**RE: Presbyterian Hospital Site Improvements
100 Central SE
Grading and Drainage Plan
Engineer's Stamp Date: 7/31/19
Hydrology File: K15D005**

Based on the submittal received on 8/7/19, the Grading and Drainage Plan cannot be approved until the following corrections are made:

A1 EXISTING DRAINAGE MANAGEMENT PLAN - SOUTHWEST LOT
1" = 20'-0"

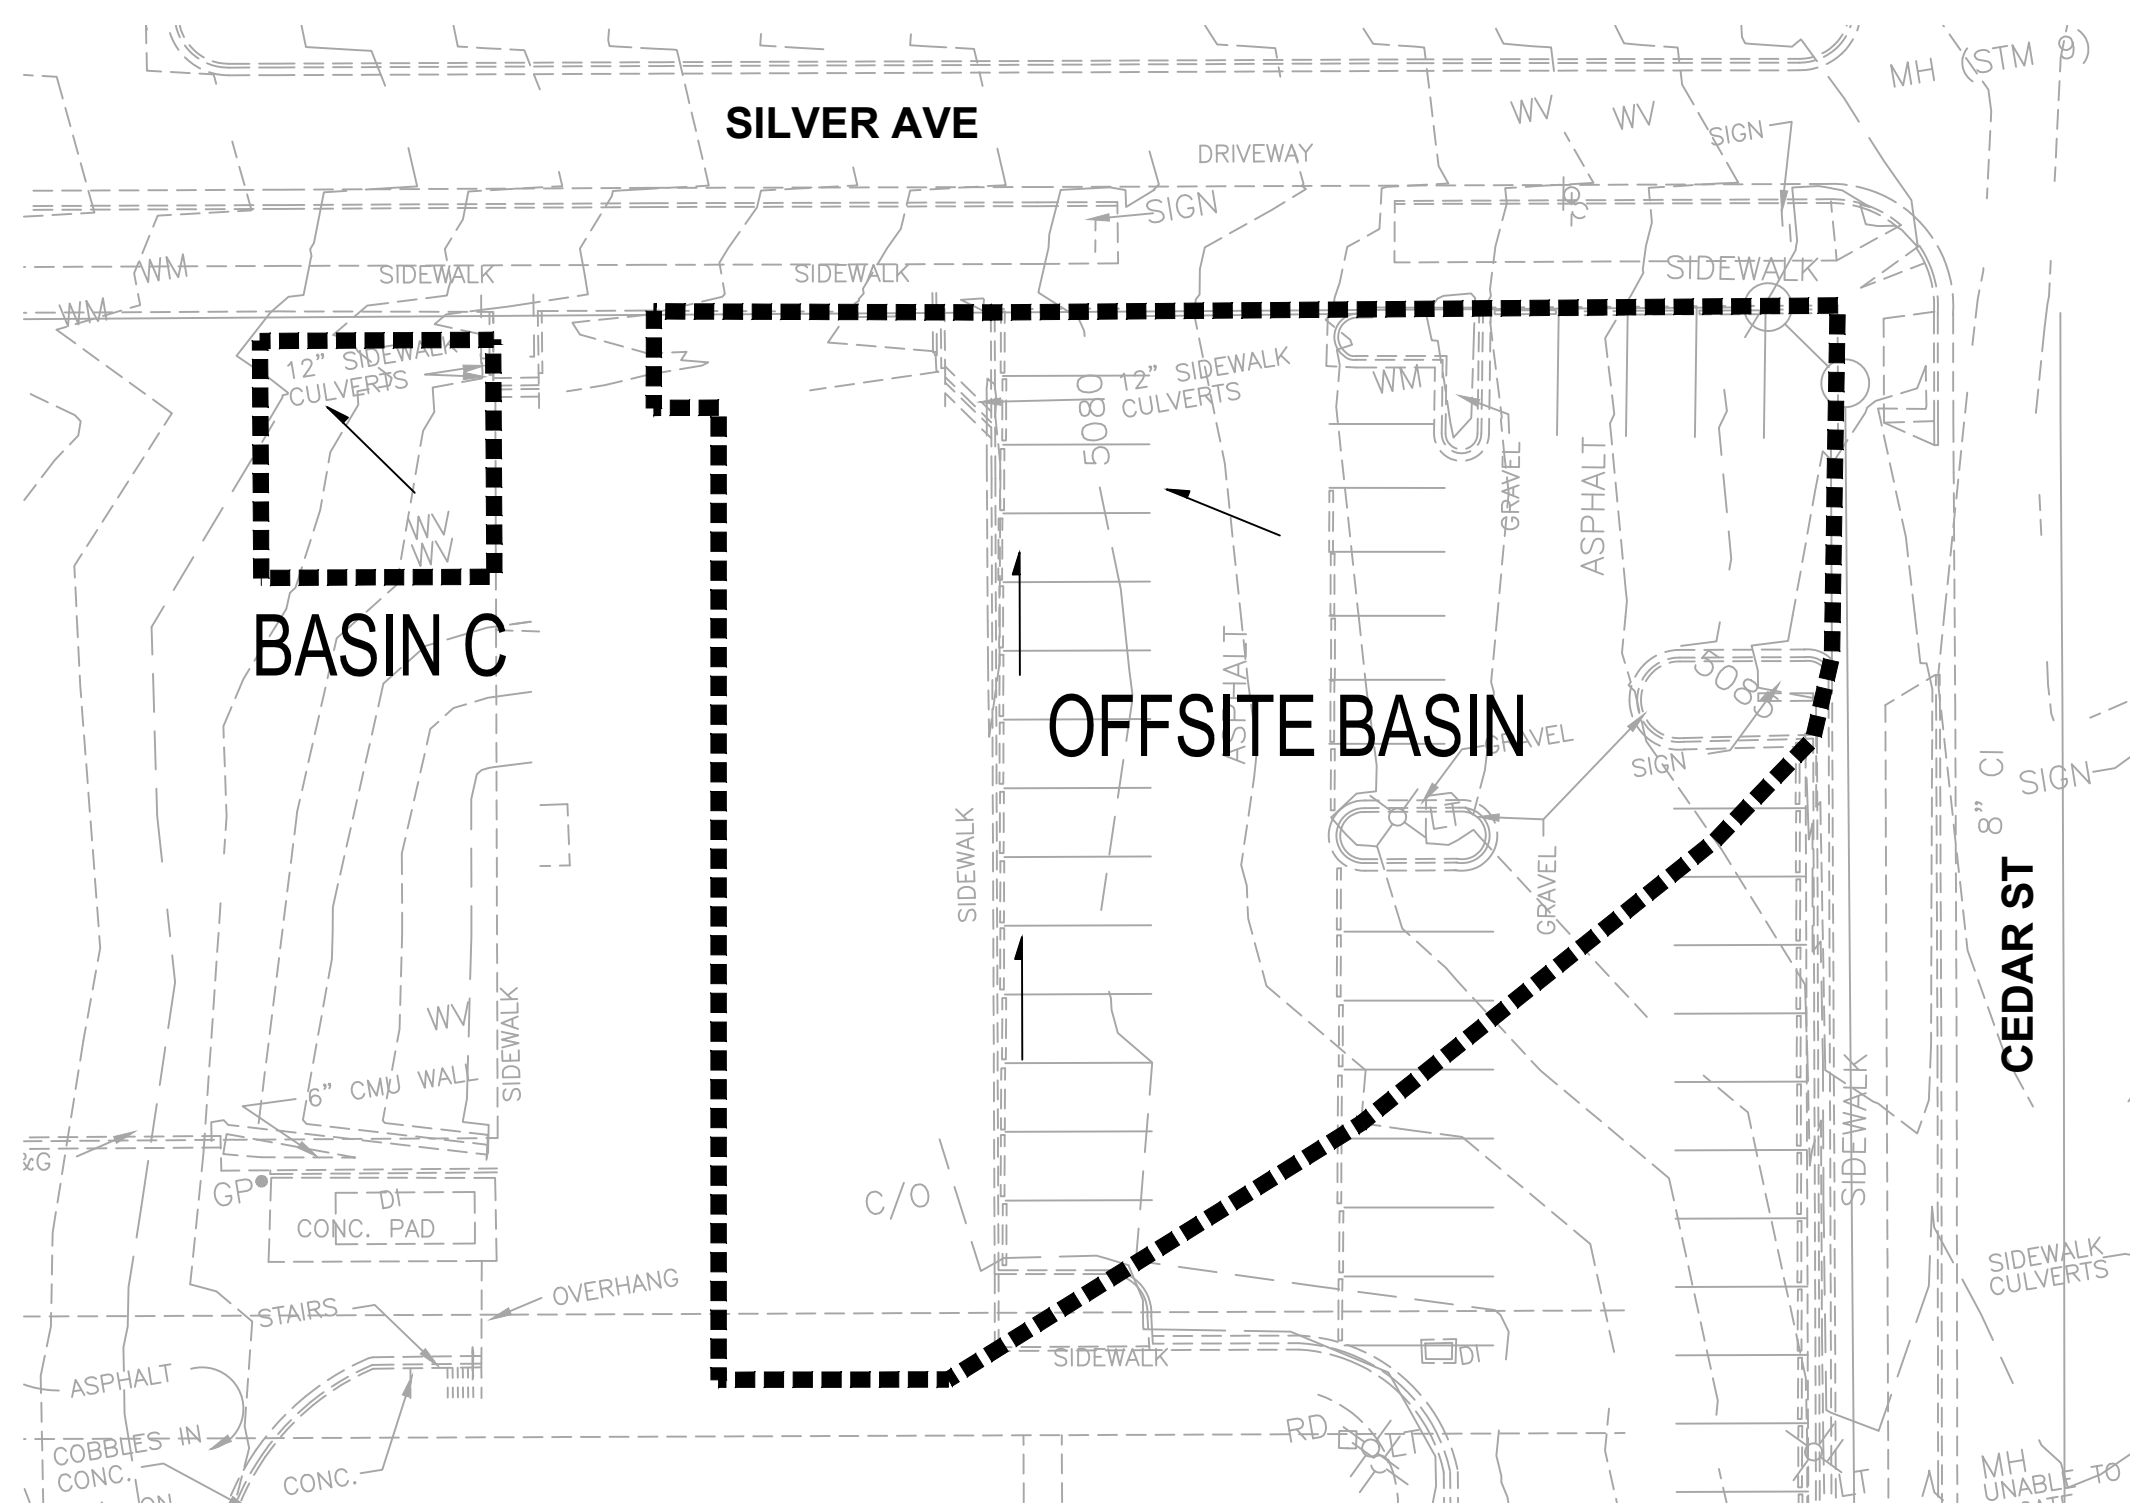
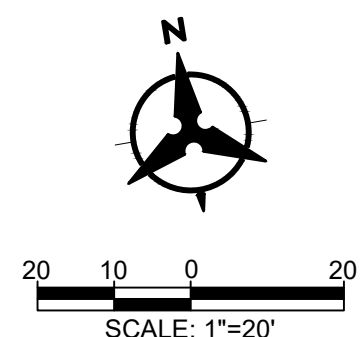
2. Provide project phasing as needed and assign this portion an appropriate phase number/name.
3. Each portion of the project (viewport) needs to include the street names.

4. Screenback or turn-off the extraneous survey layers.
5. Please use the most recent [standard SO-19](#) notes on the grading plan and callout the work to be performed by SO-19 Permit. If a Work Order is required than the SO-19 work will have to be performed by Work Order, not SO-19.

6. Provide management onsite for the Stormwater Quality Volume (SWQV) in accordance with the new drainage ordinance, § 14-5-2-6 (H) enacted 10/2/18 (Council Bill C/S O-18-2). You may elect to make Payment-in-Lieu of onsite management for the volume not captured. In order to pursue this, the plan must state that: you could provide onsite management, you do not want to (due to cost or convenience), and you are electing to make the Payment in Lieu of onsite management.

7. This site qualifies as redevelopment and is only required to retain runoff from the 80th percentile storm (Vol. = 0.26''*Imp.Area).

8. Include project benchmark and datum; all existing survey, proposed grades, and benchmarks must be provided in NAVD 88.
9. Payment in Lieu (Amount = TBD) of onsite management of the SWQV must be made.
10. Hydraulic calculations per the DPM Ch.22.3 are required for all sidewalk culverts, swales, storm drain, etc...
11. As a reminder, if the project total area of disturbance (including the staging area and any work within the adjacent Right-of-Way) is 1 acre or more, then an Erosion and Sediment Control (ESC) Plan and Owner's certified Notice of Intent (NOI) is required to be submitted to the Stormwater Quality Engineer (Doug Hughes, PE, dhughes@cabq.gov, 924-3420) 14 days prior to any earth disturbance.
